Our ref: WA/2015/119522/02-L01

Your ref: 14/02121/OUT

Date: 12 October 2015

Proposed Himley Village, North West Bicester, Middleton Stoney Road, Bicester, Oxfordshire.

HIMLEY VILLAGE NW BICESTER	
EXISTING SITE LOCATION PLAN SHOWING EXISTING WATERCOURSES AND EXISTING SURFACE WATER DRAINAGE LAYOUT	
1665/76/ SK102	
MAY 2015	Alan Baxter

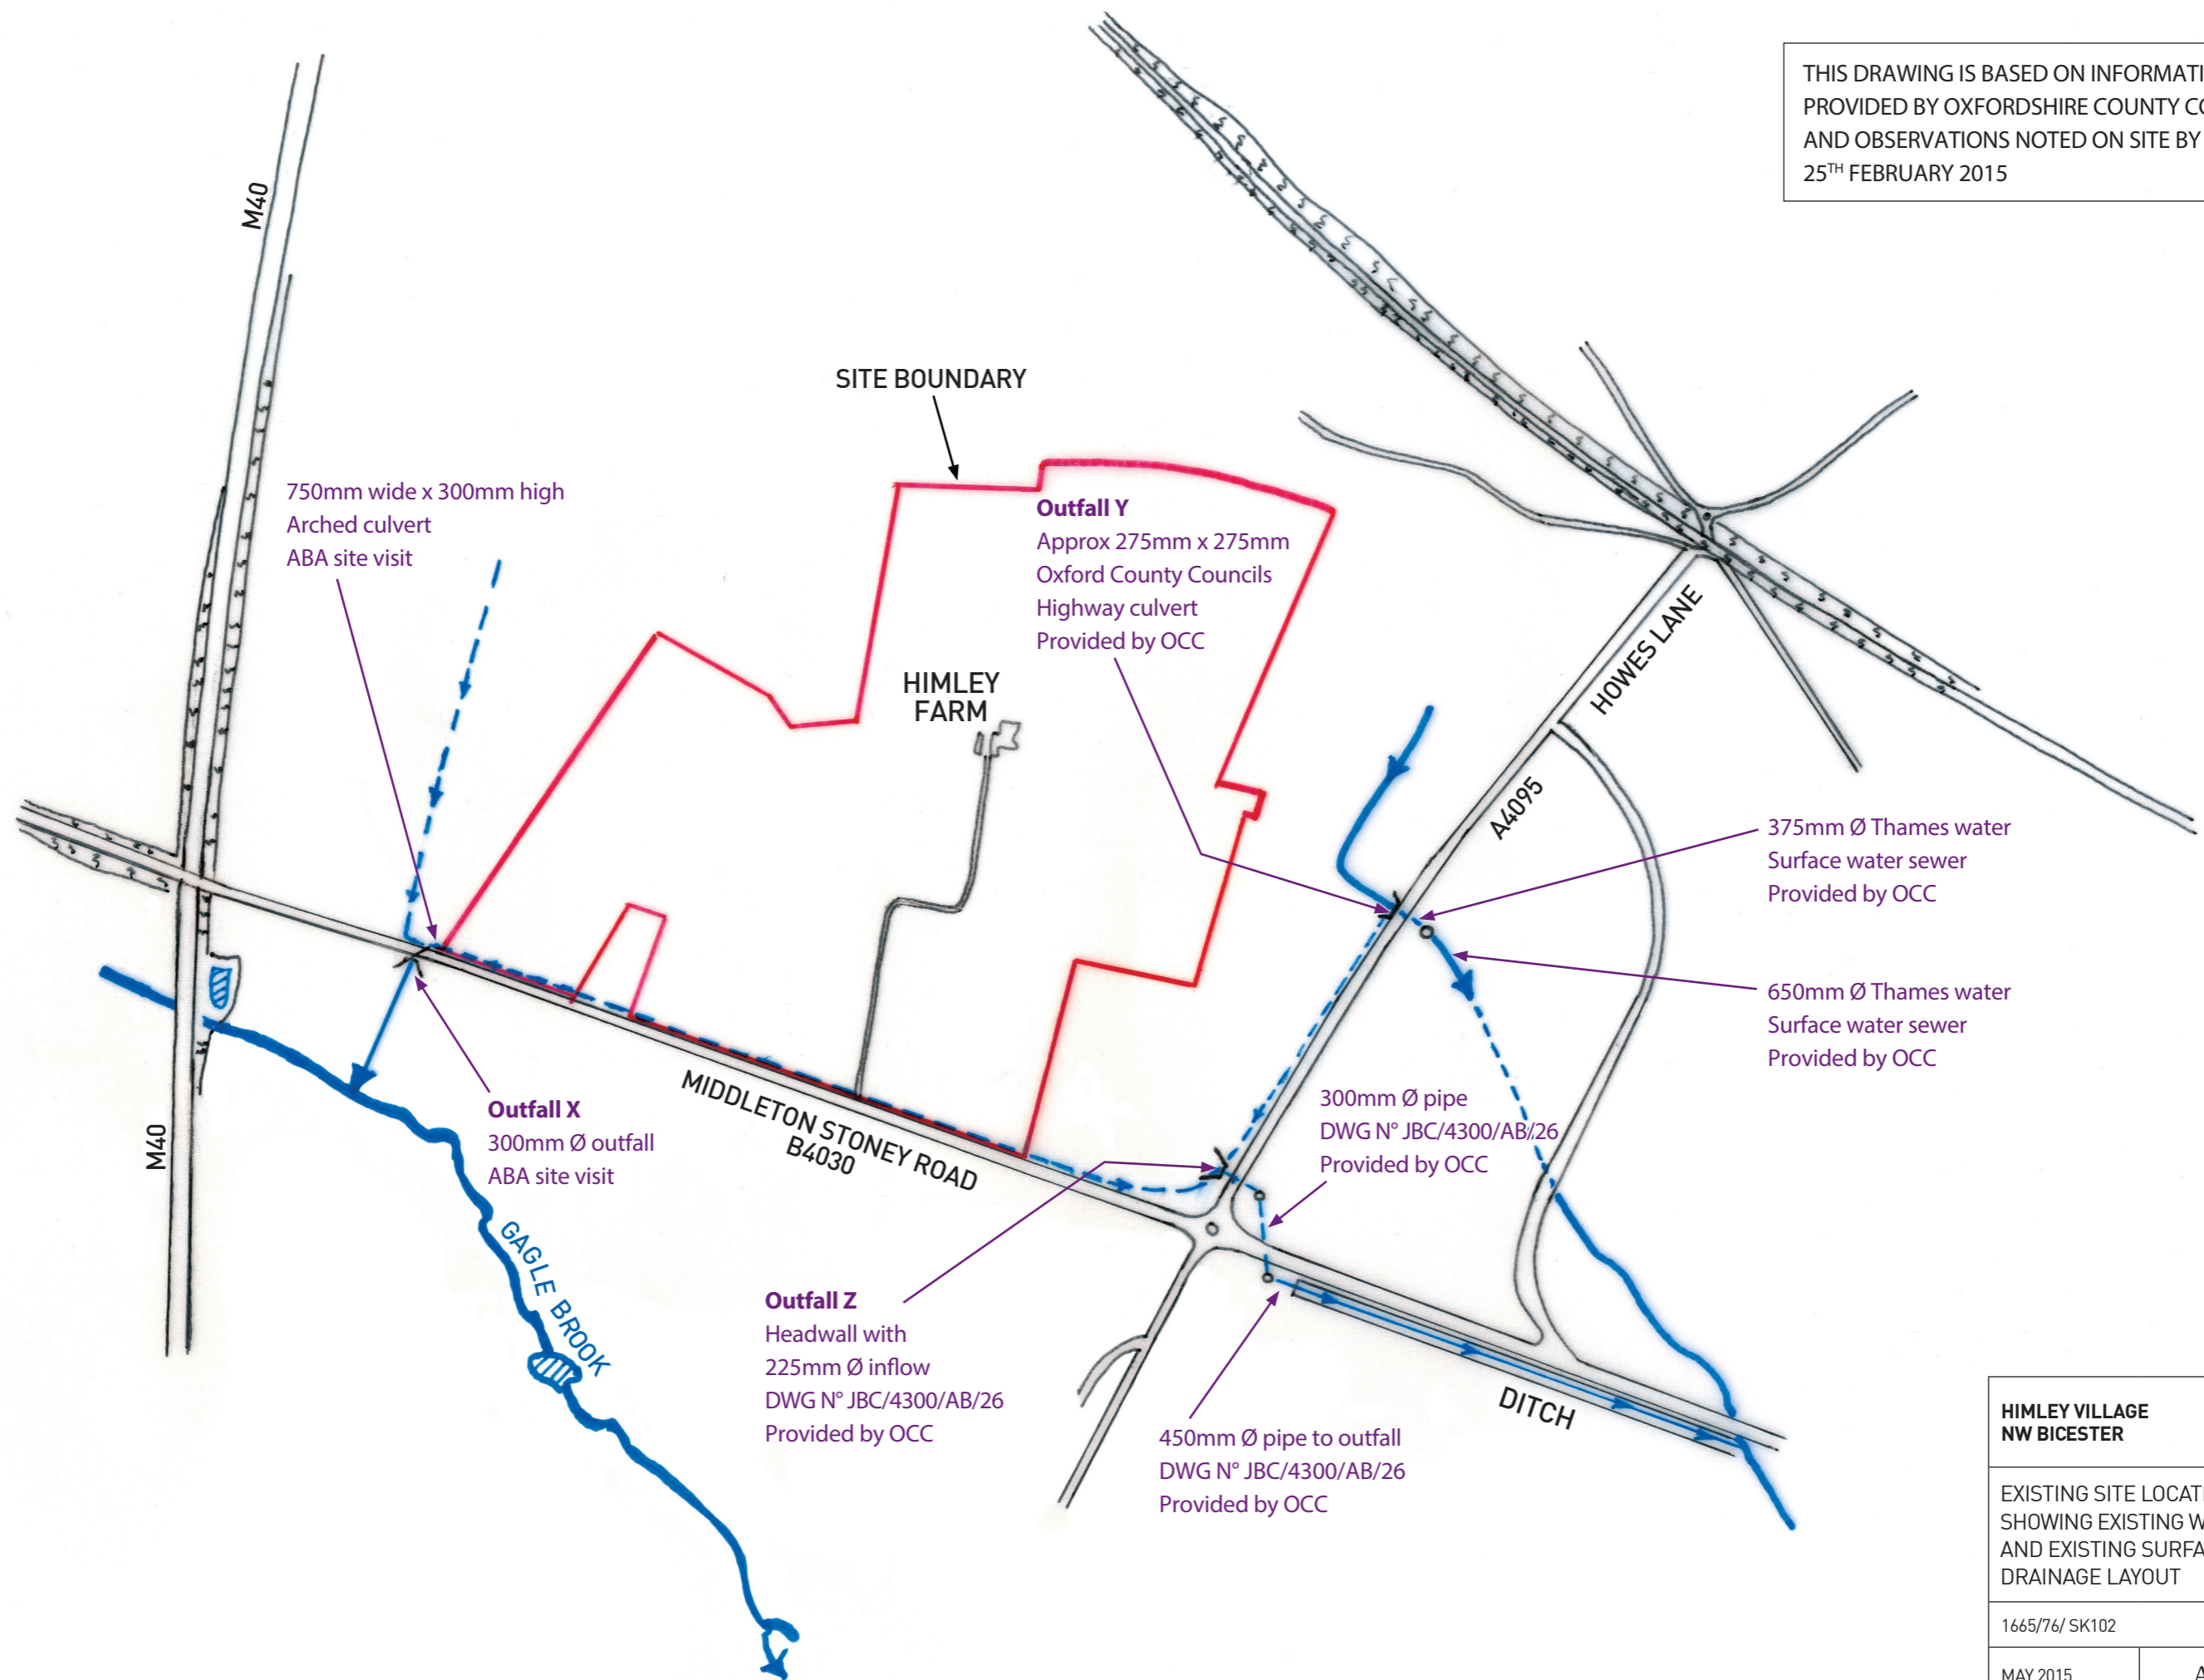
Drawing 1665/76/ SK102 (existing site location plan showing existing watercourses and existing surface water drainage layout)

This shows that further investigation has been carried out of the culverts acting as proposed discharge points for surface water from the development. Some of these culverts are small but the information on the plan indicates they are viable discharge points. Discharge rates are to be limited to below 2l/s/ha - less than existing Greenfield runoff.

orig. no. 1665/75/04	rev.
--------------------------------	------

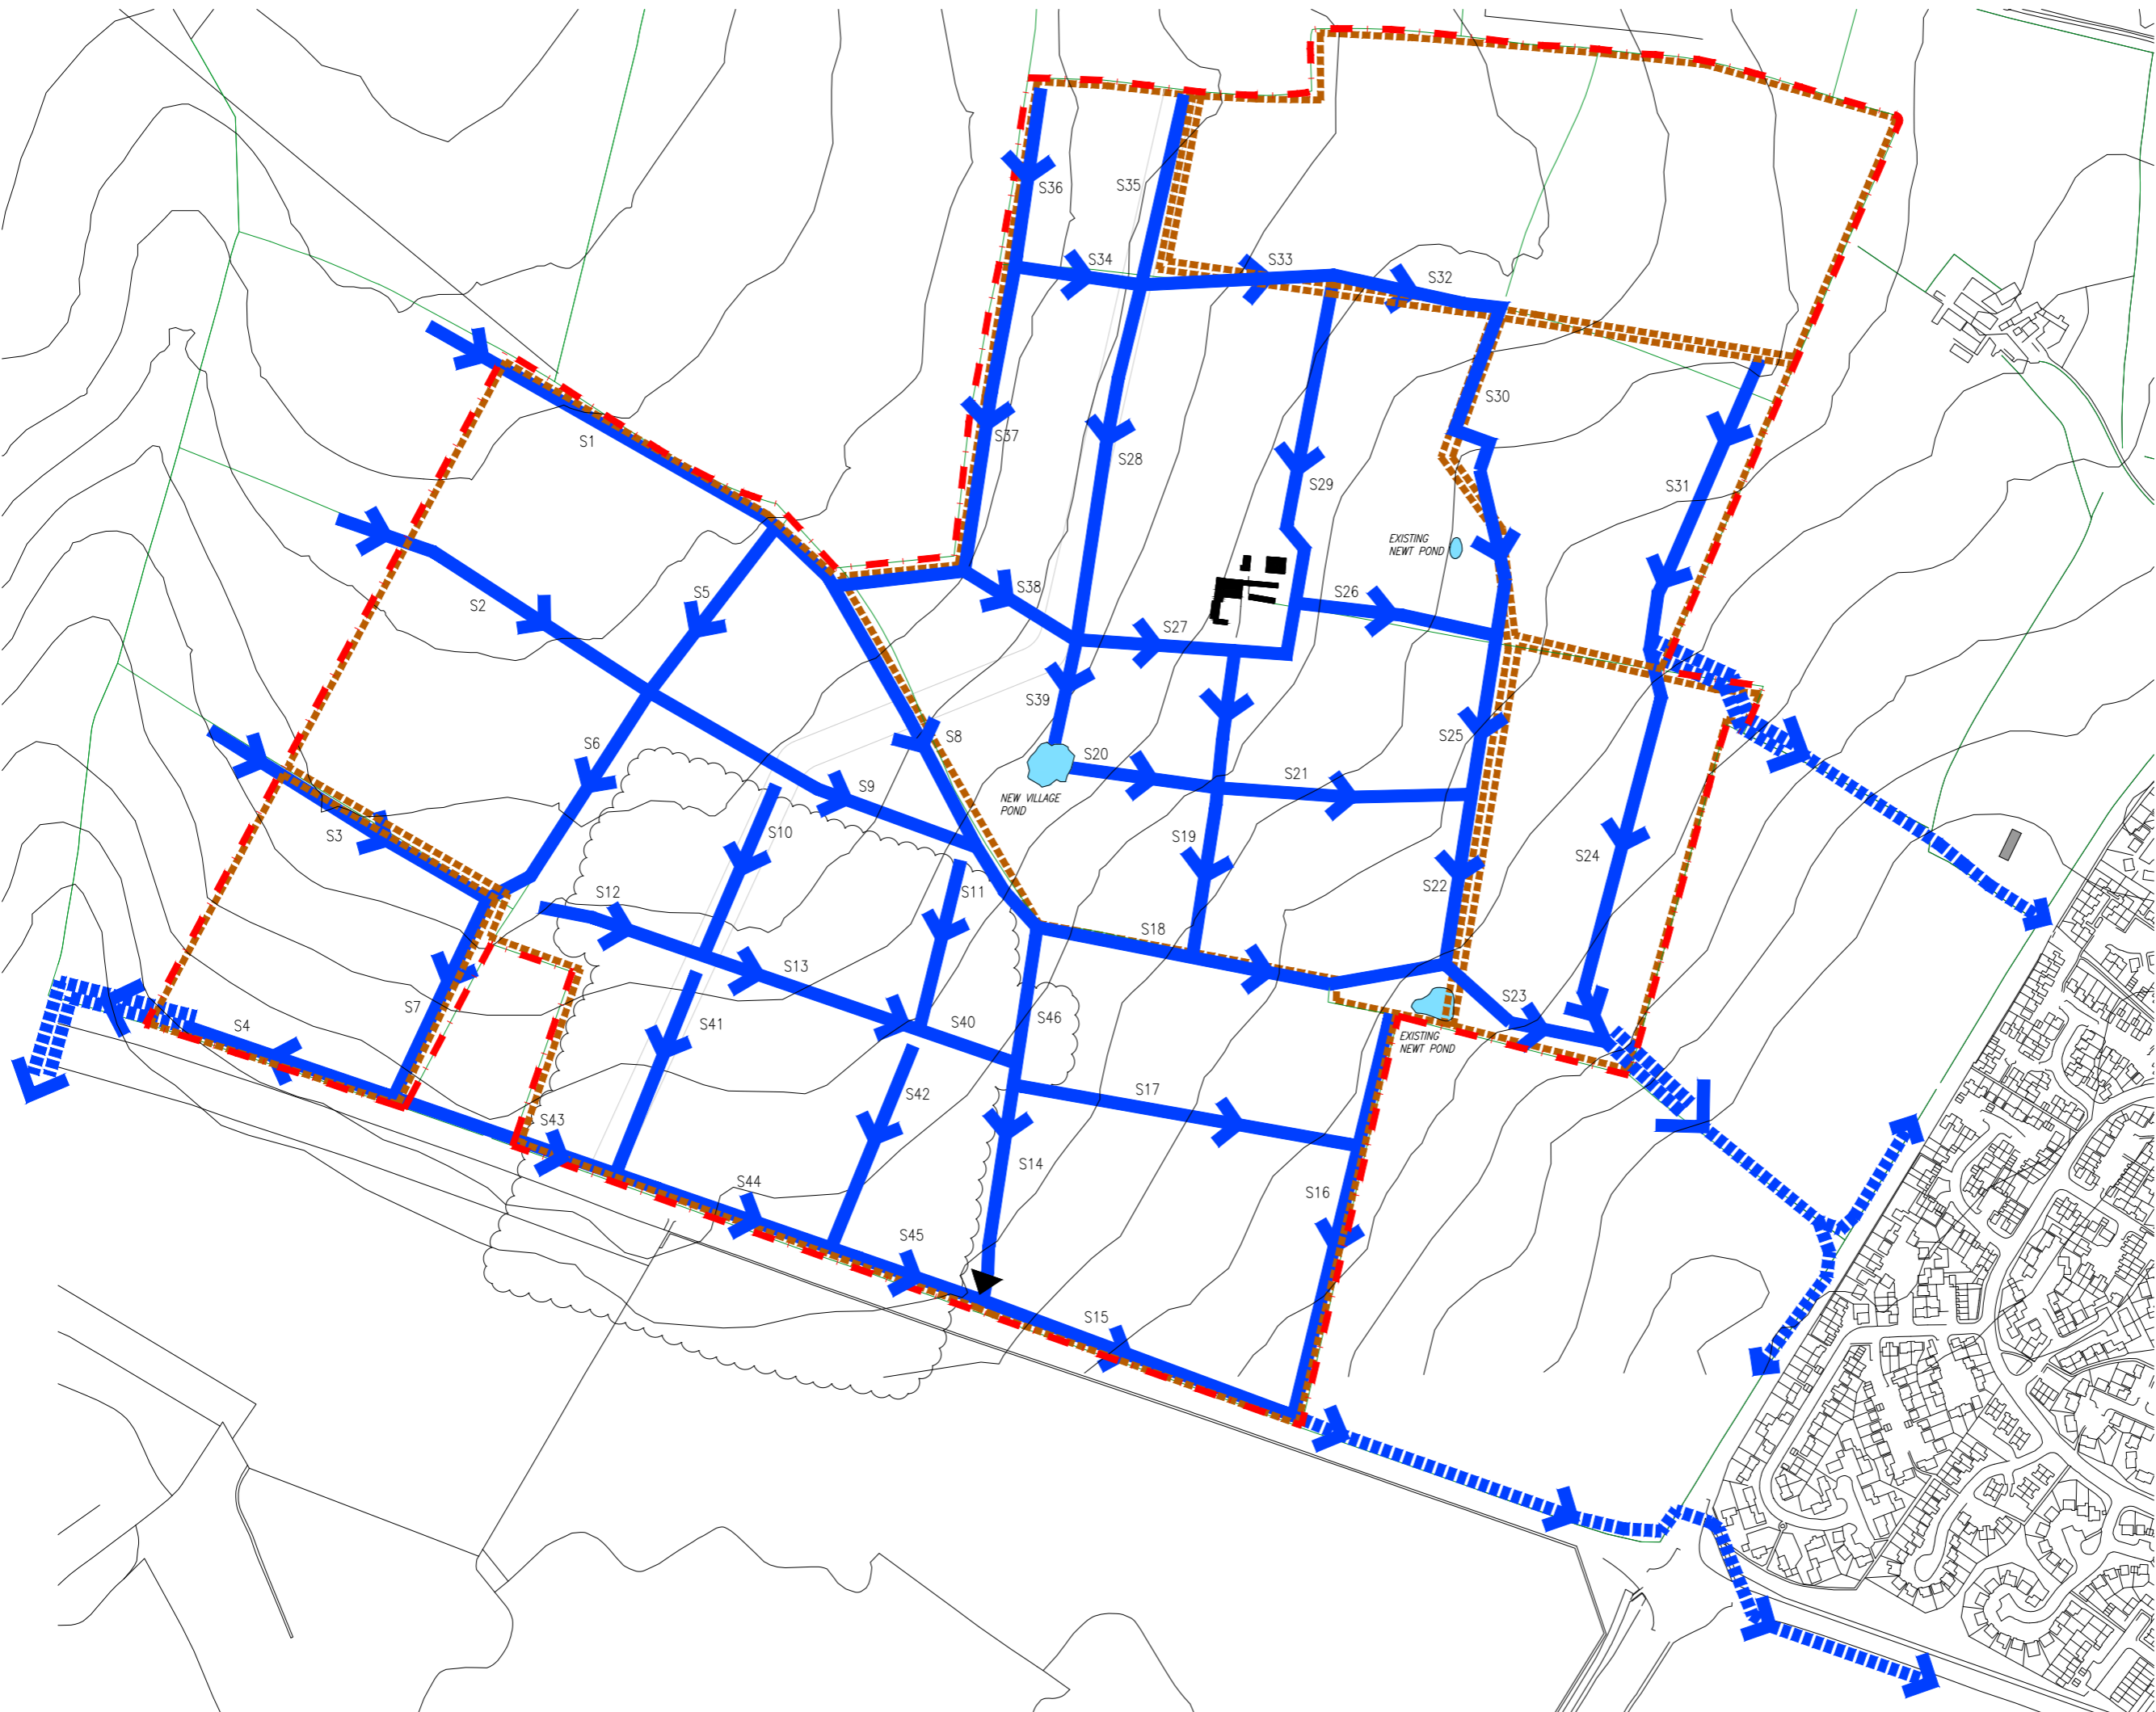
Drawing 1665/75/05 rev B (suds parameter plan)

This shows the extent of proposed swales across the site. The associated table shows that the volume of surface water storage required to limit run-off to the proposed 2l/s/ha can be contained within the proposed swales.
